**Advice for Griffith Base Hospital Redevelopment (SSD-9838218) Environmental Impact Statement – Aboriginal cultural heritage**

Thank you for the referral dated 28 April 2021 inviting comments from Heritage NSW on the exhibited Griffith Base Hospital Redevelopment Environmental Impact Statement (EIS) for this State Significant Development (SSD).

Figure 8: AHIP boundary edged in yellow.

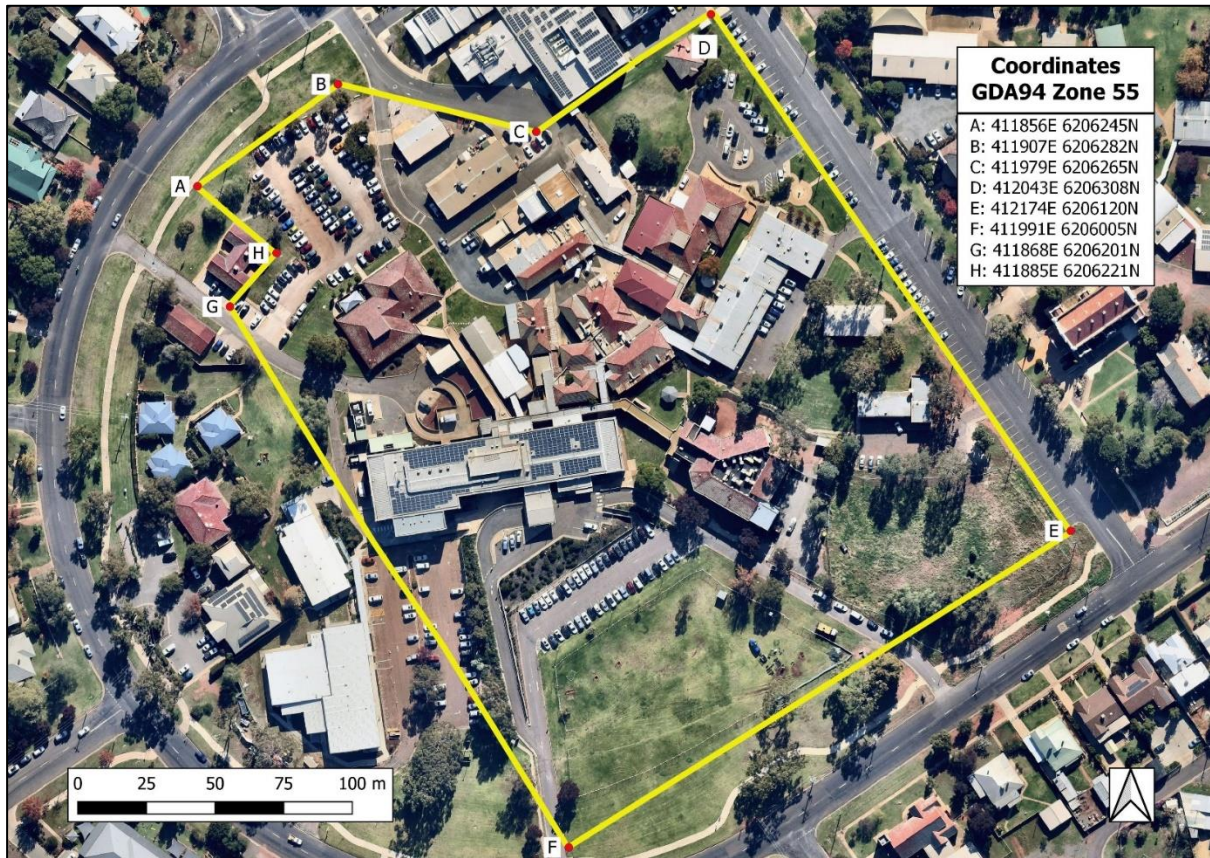
- The ACHAR does not contain a map showing the SSD boundary to support the statement that only PAD 5 is within the SSD boundary (2021:19).
- Consultation was undertaken in accordance with the '[Aboriginal Cultural Heritage Consultation Requirements for Proponents](#)' (DECCW 2010). The results of consultation are documented in the ACHAR (Comber Consultants, 2021).

- (c) Include a map showing the SSD boundary, AHIP 4667 boundary and the extent of site 49-2-0180. The purpose of the map will be to inform the approval pathway (SSD or AHIP) and management options, if Aboriginal objects are uncovered during works.
